Our Ref: BE/87/17/NMA

Application for A Non-material Amendment Following a Grant of Planning Permission

Development Application for a non- material amendment following the grant of BE/45/16/PL relating to alterations to elevation treatments, change of roof pitch & changes to window style.

Location 27 North Bersted Street Bognor Regis

Type 02 (proposed)
House Elevations

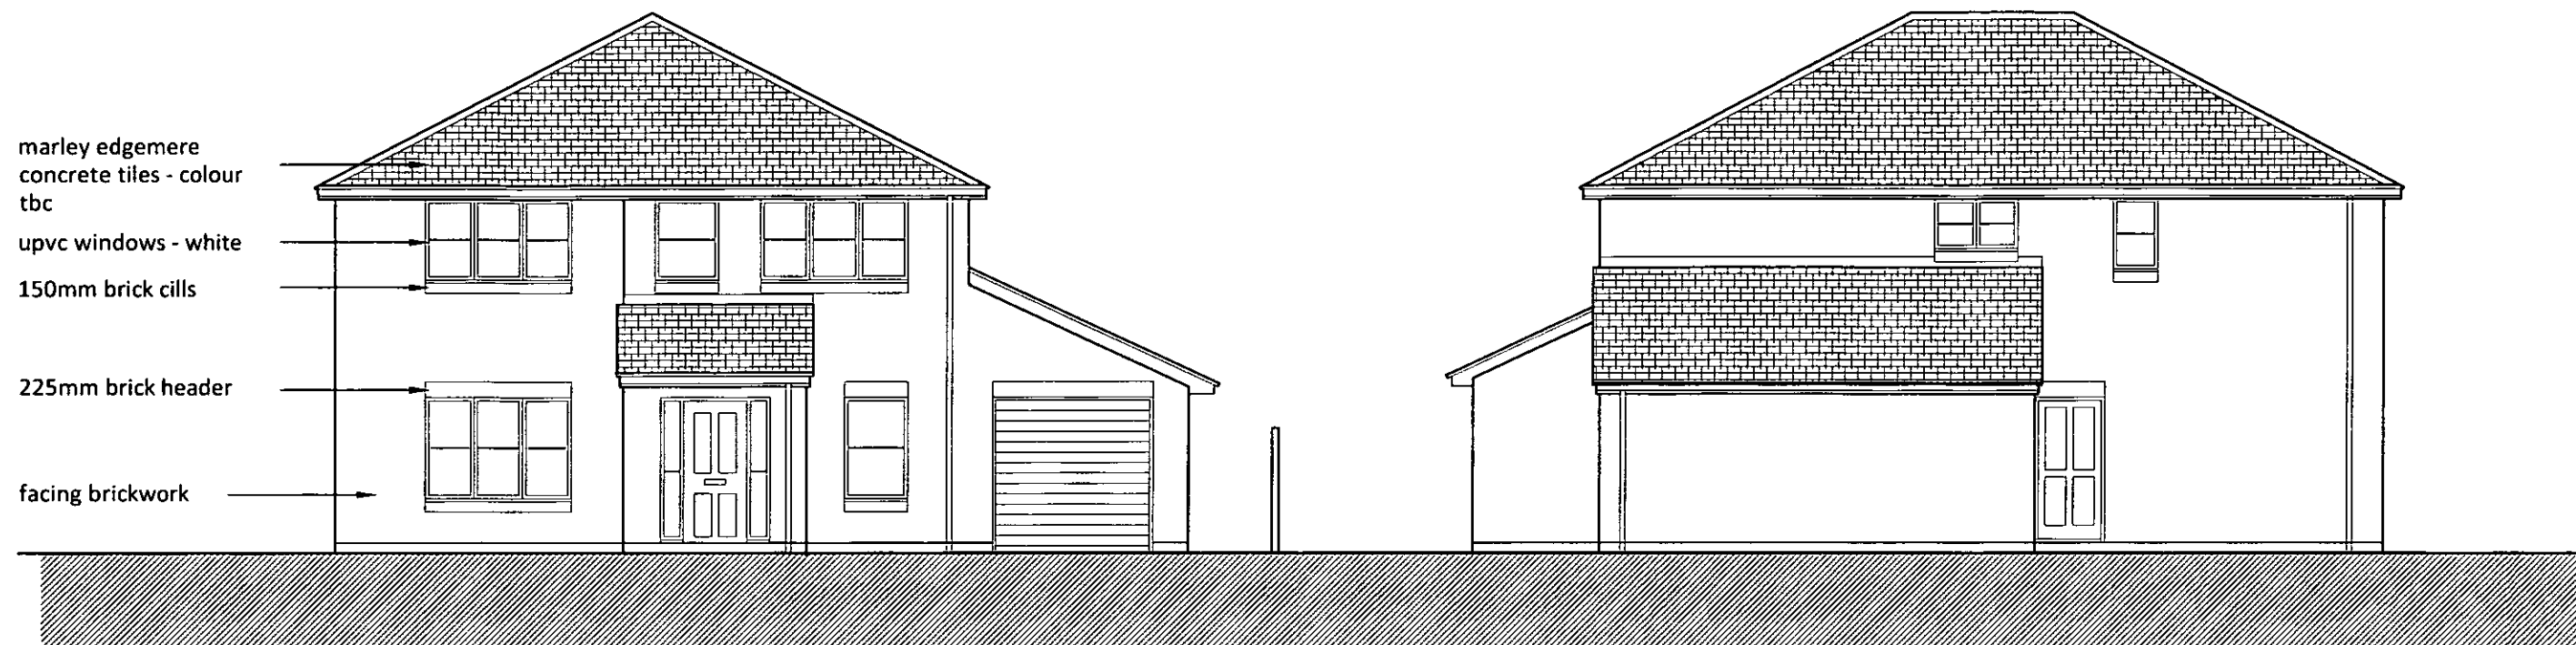
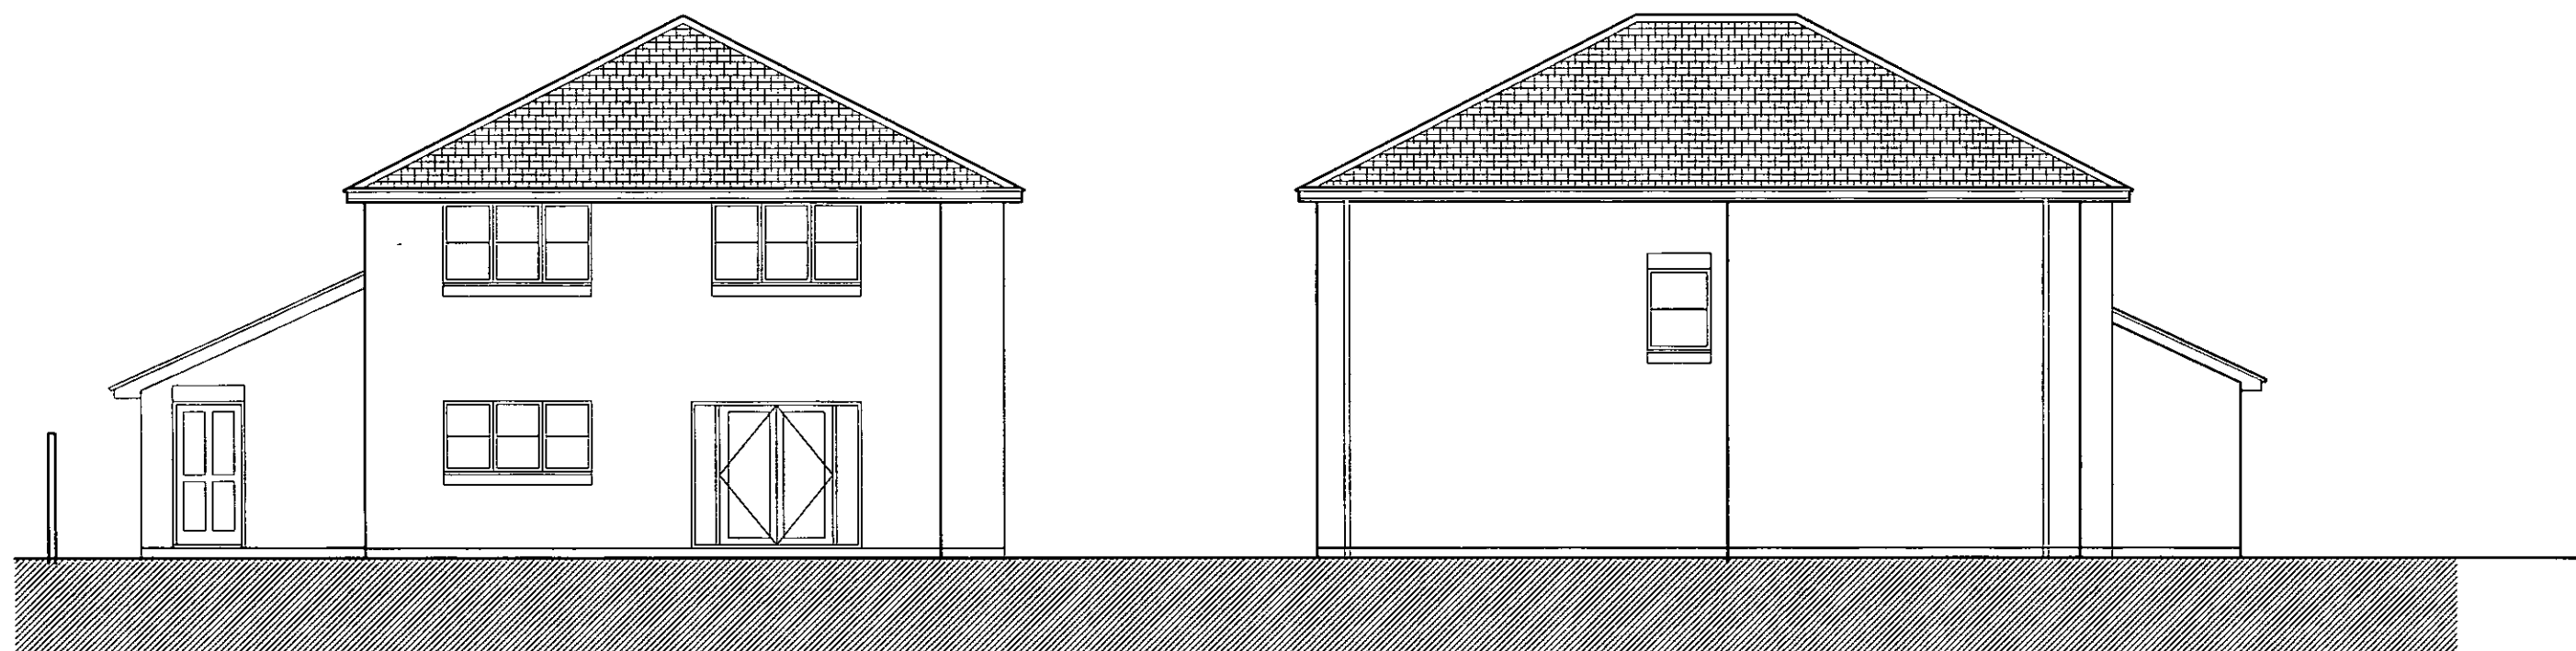
Plans 5015 and 5016 (proposed Type 02) side elevation and floor plan do not accord. Please amend accordingly.

Type 03 (proposed)
House Elevations

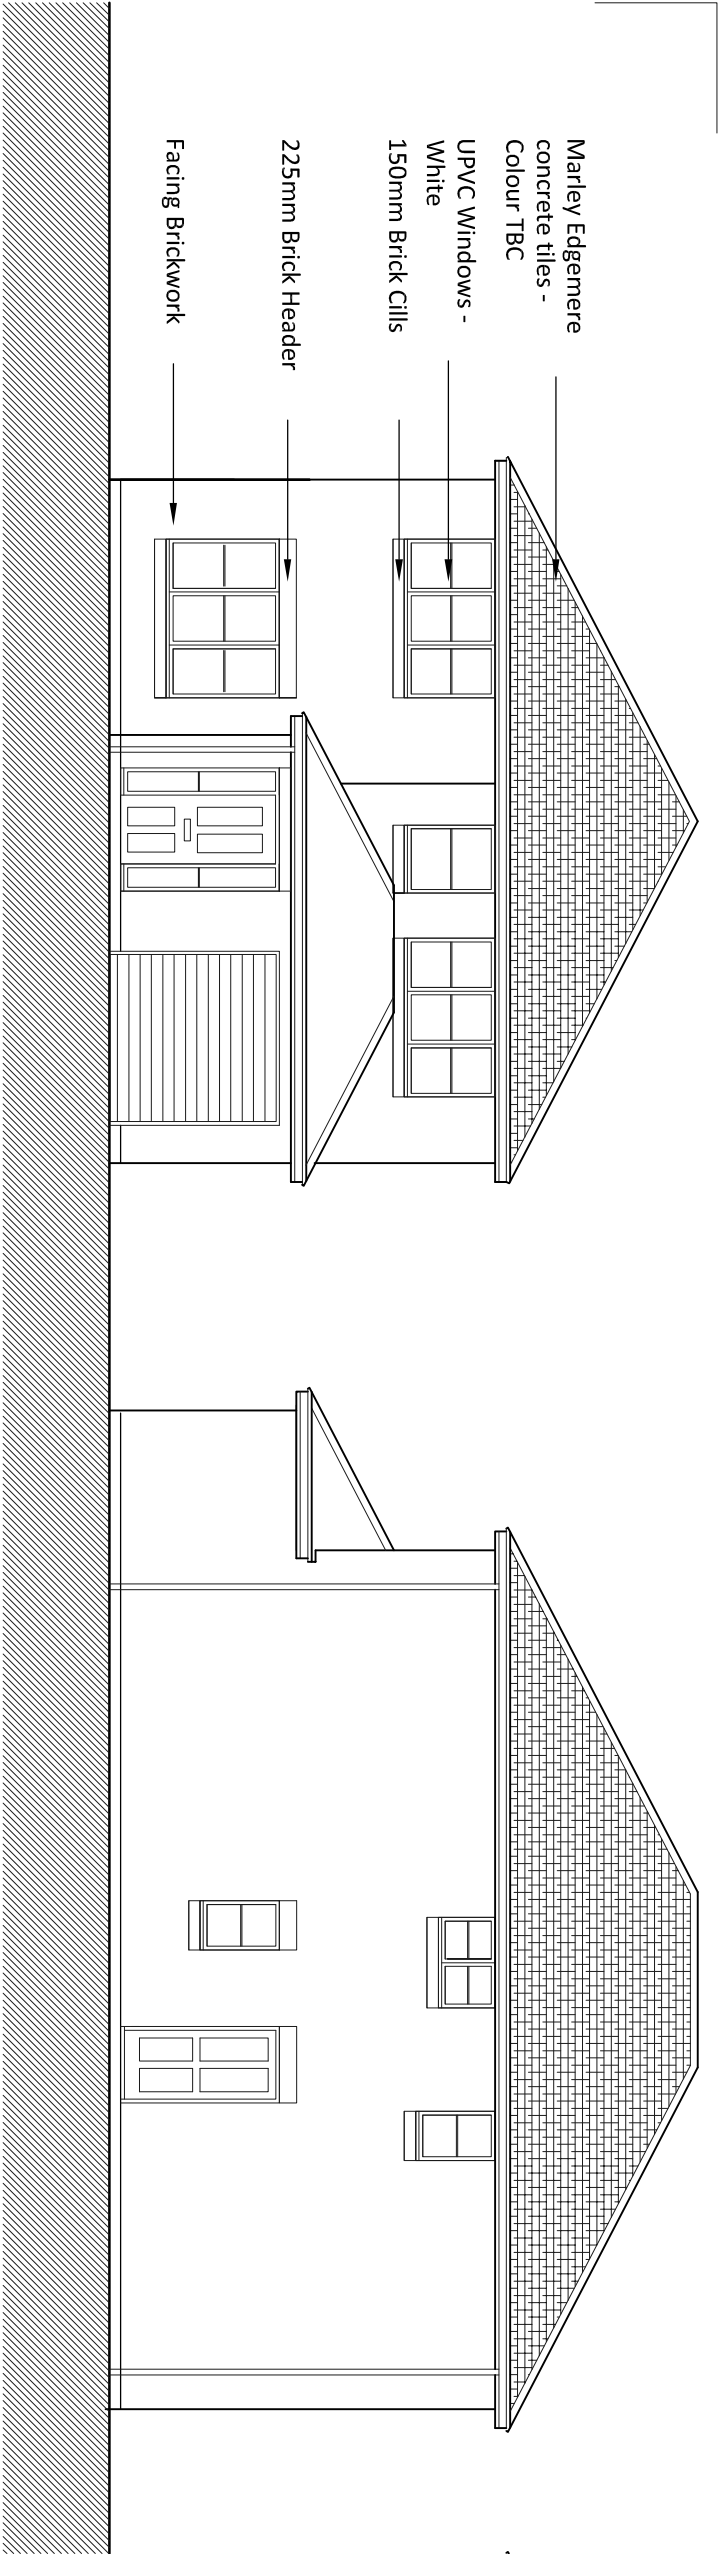
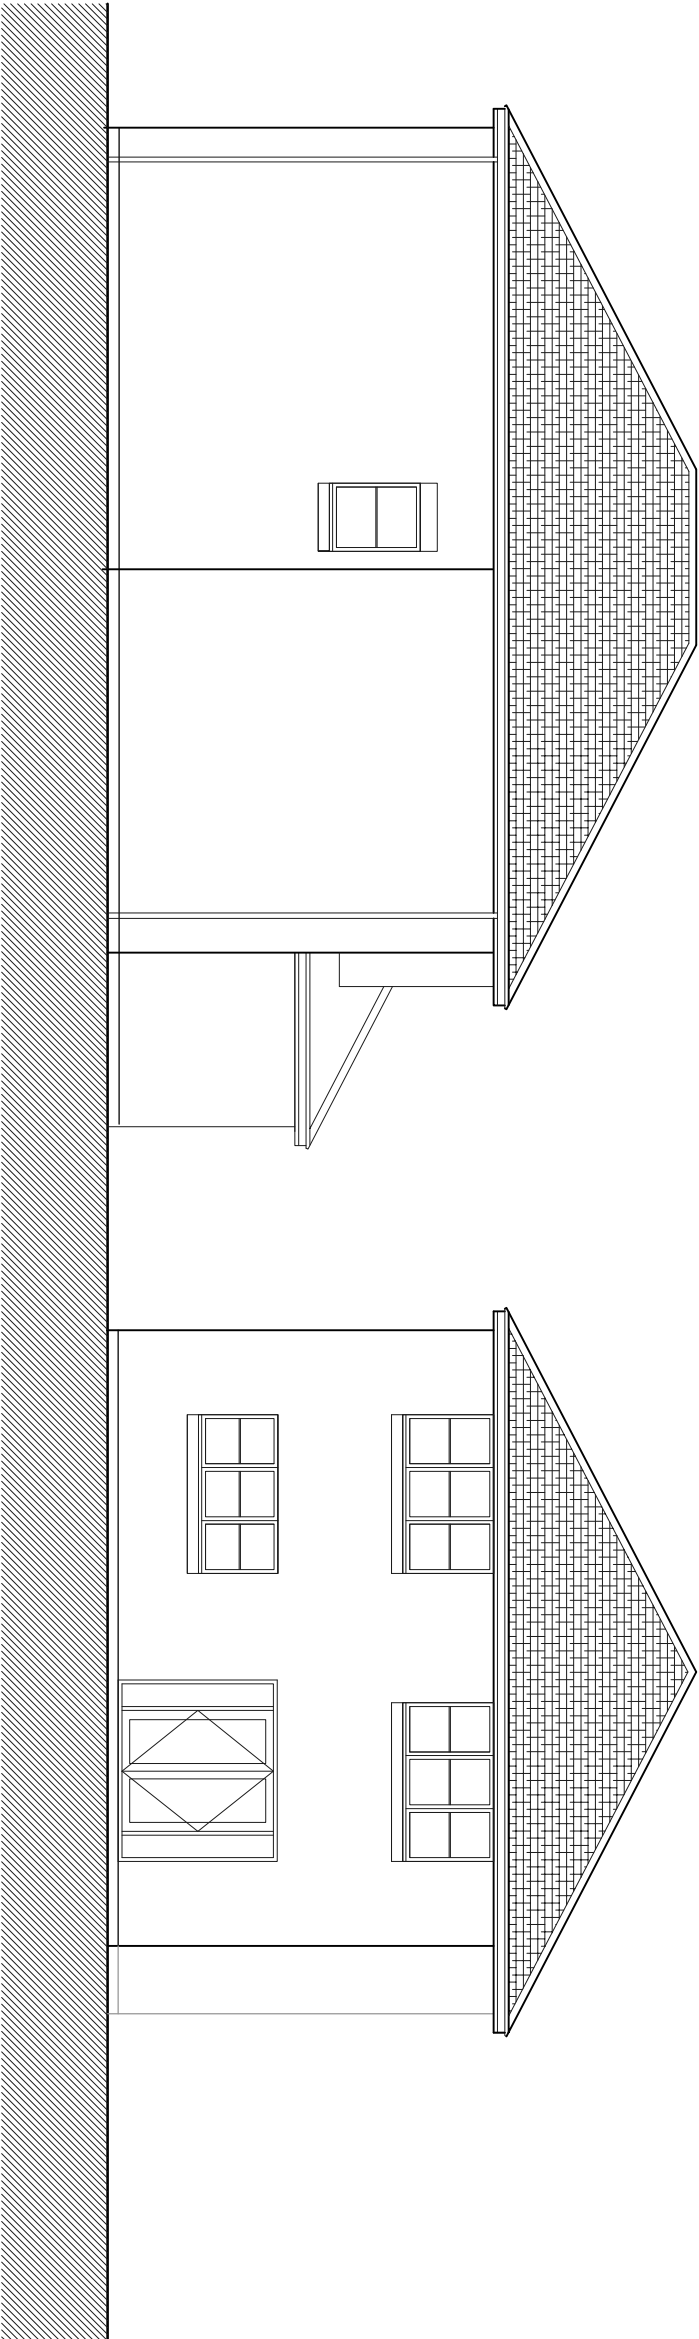
Plans 5017 and 5018 (proposed Type 03) floor plans and elevations do not accord. Please amend accordingly.

Type 04 (existing)
House Plans

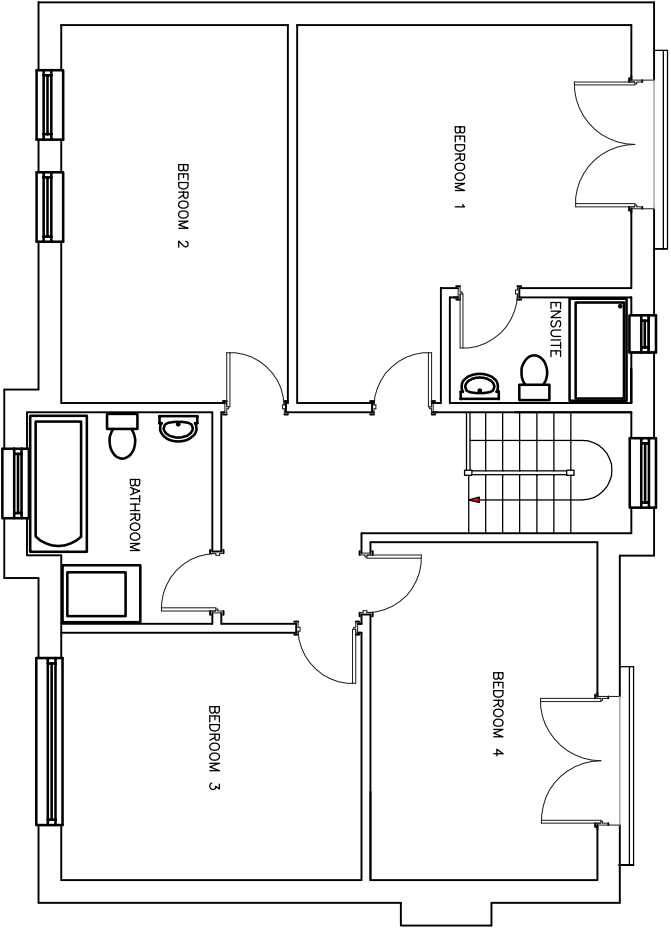
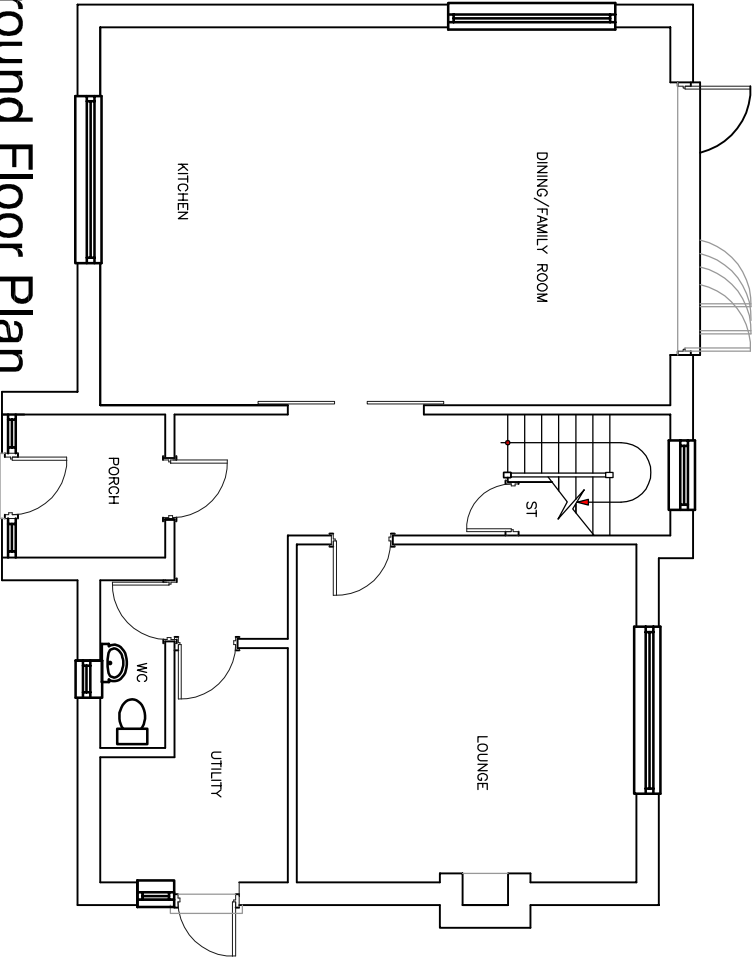
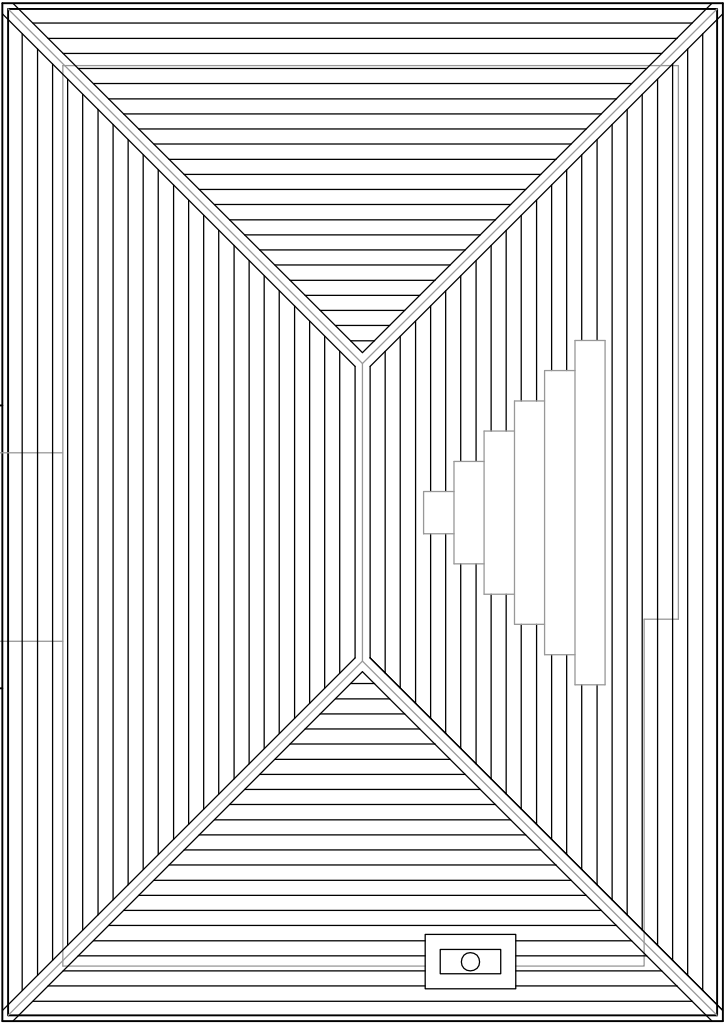
Plans 5109 and 5010 (existing Type 4) floor plans and elevations do not accord. Please amend accordingly.

Type 01a (proposed)
Bungalow Elevations

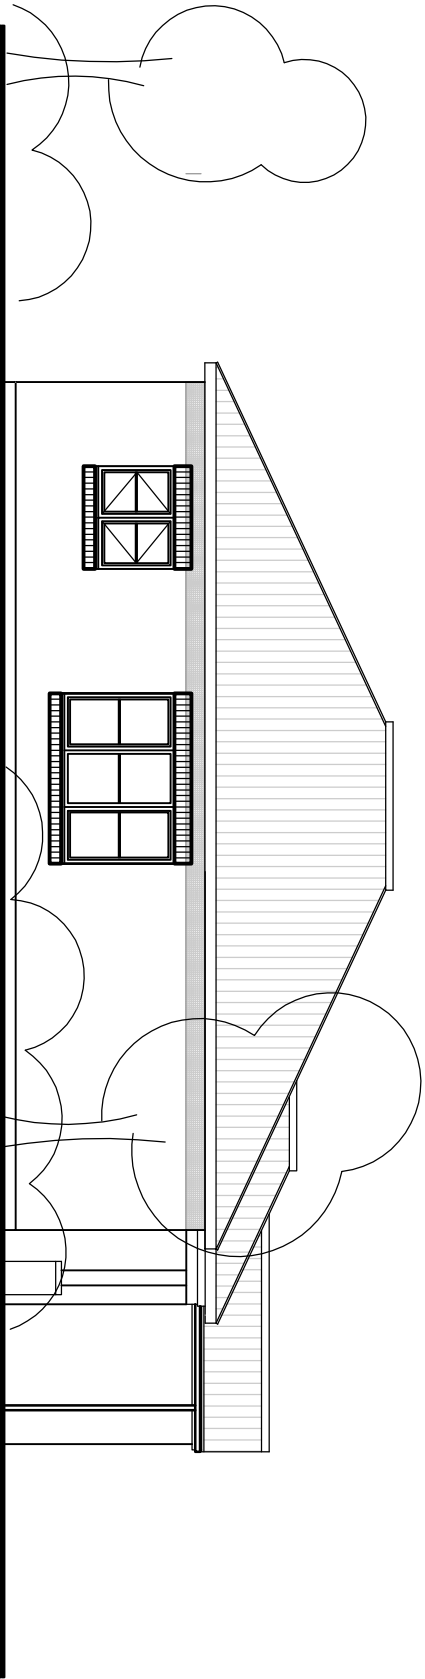
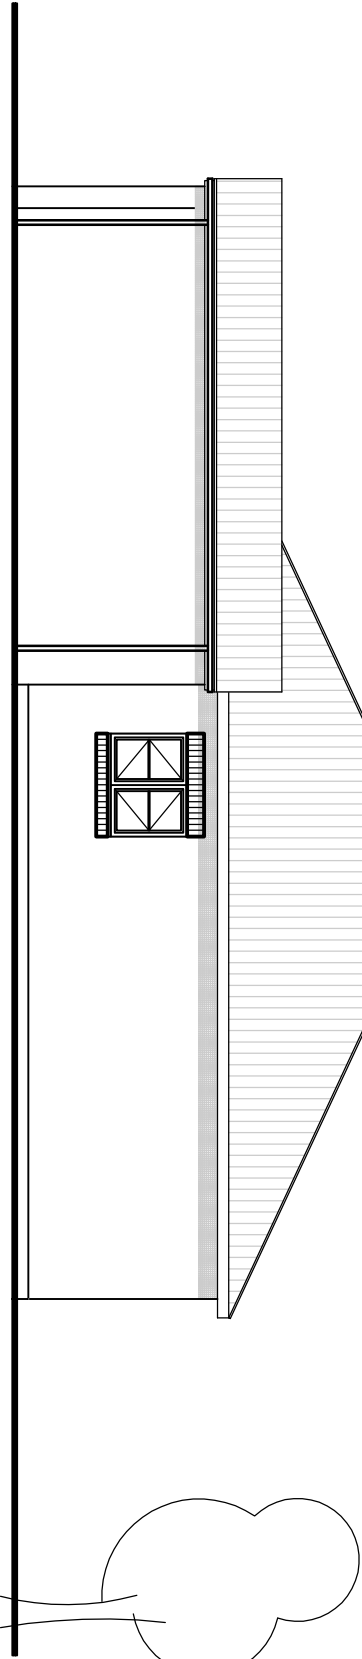
Plans 5013 and 5014 (proposed Type 01(a). SE elevation and floor plan do not accord. Please amend accordingly.
